### **STAGE 1 DEVELOPEMNT AT NEWCASTLE GRAMMAR SCHOOL - PARK CAMPUS SSD-13895306 – EOTH21-00261**

I am writing regarding the request to provide advice on the above proposal, including any recommended conditions regarding Stage 1 of a major redevelopment of Newcastle Grammar School, Park Campus. Subsidence Advisory NSW (SA NSW) understands that Stage 1 comprises a new 3-storey classroom building.

Concept Arrangement
Piling

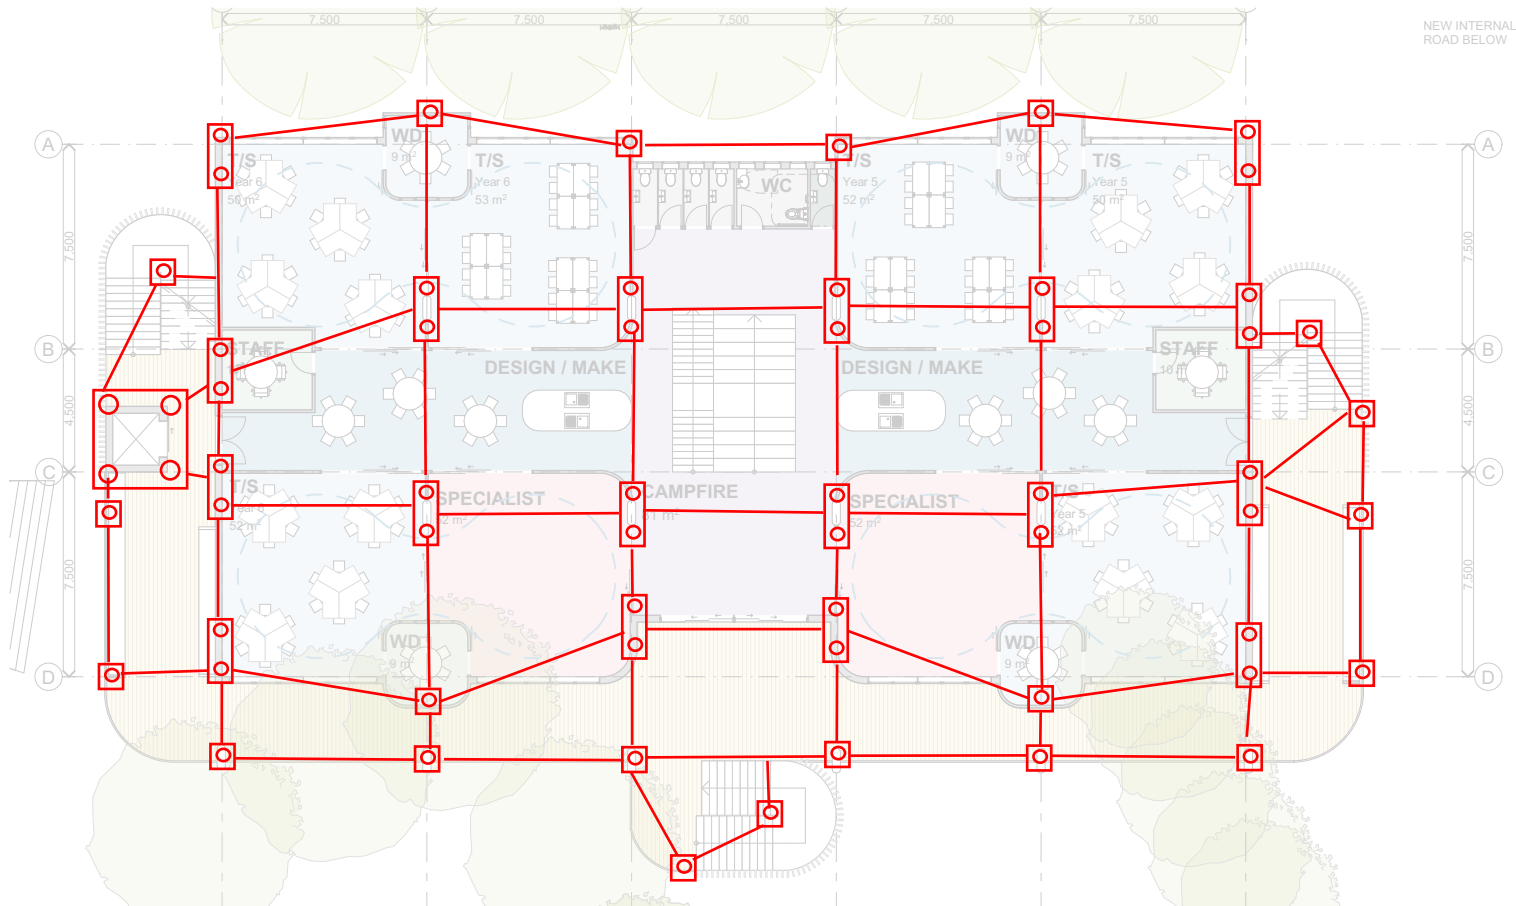
It is recommended that the applicant provide the parameters contained in the TT Coffey Mine Subsidence Investigation and Assessment report to the project structural engineer for the Stage 1, new 3-storey building.

SA NSW merit policy for B3 development requires the provision of certification from a qualified structural engineer that the proposed structure is capable of remaining “safe, serviceable and any damage from mine subsidence shall be limited to ‘very slight’ damage in accordance with AS2870 (Damage Classification), and readily repairable” if subjected to the subsidence parameters provided in the TT Coffey report (see Section 6). If the parameters are outside the range of designable parameters for the building, grouting of the abandoned workings may be required.
